Subject: Ivanhoe Estate Stage 2 Building C4 (SSD-15822622-Mod-5)

**Letter of response to Department of Planning, Housing and Industry Comments**

This letter has been prepared in response to relevant traffic, transport and parking matters raised in the Request for Response of submission (Request for Response) by the Department of Planning, Housing and Industry (DPHI) in relation to SSD-15822622-Mod-5.

Figure 1: Proposed modified ground floor plan

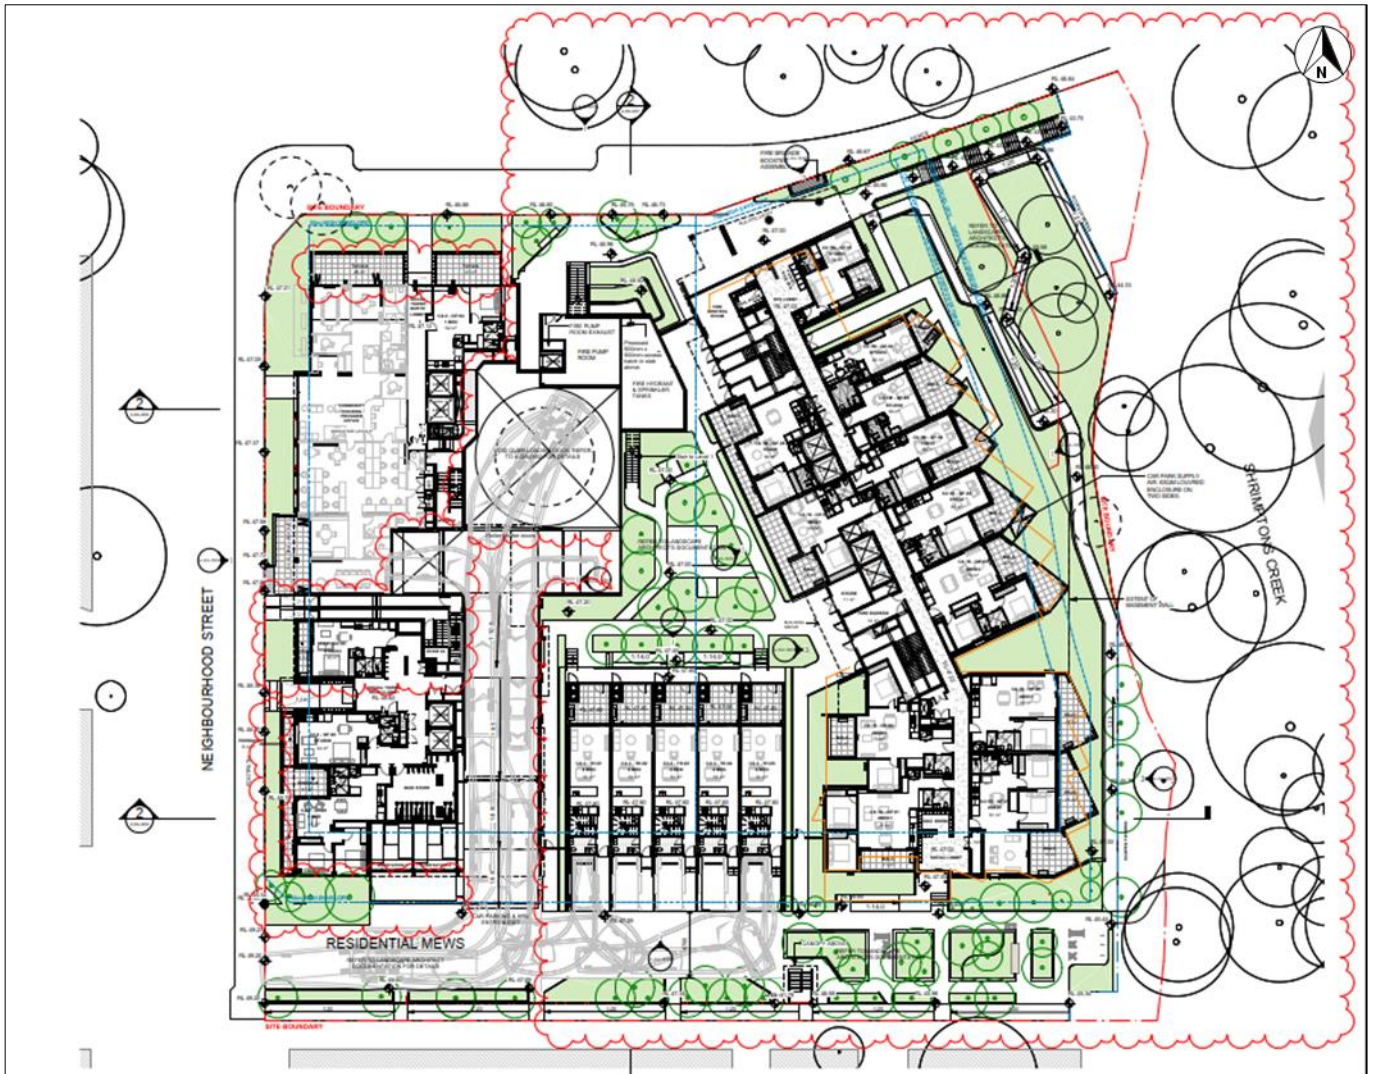
*Provide updated swept paths for an HRV to AS2890.02 showing entry to the building and exit via Mews Road. Paths must demonstrate access does not conflict other passenger vehicles entering and exiting the building. The current traffic statement does not show HRV access from Mews Road*

A range of vehicle swept paths were completed as part of the modification application transport statement. This included 12.5m heavy rigid vehicles passing 99<sup>th</sup> percentile cars along the main access ramp. Additional swept paths are included in Appendix A and show full independence for cars and 6.4m small rigid vehicles, with management measures expected to be in place at times when large service vehicles need to infrequently access the site.

Overall, no material changes are proposed to the site access arrangements as approved under SSD-15822622-Mod-3. This includes maintaining the previously approved access on Mews Road noting that the proposed access width of 8.7m readily exceeds the minimum requirements of relevant Australian Standards and facilitates all relevant design vehicles. The approved SSD-Mod-3 and proposed Mod-5 plans are shown in Figure 1.
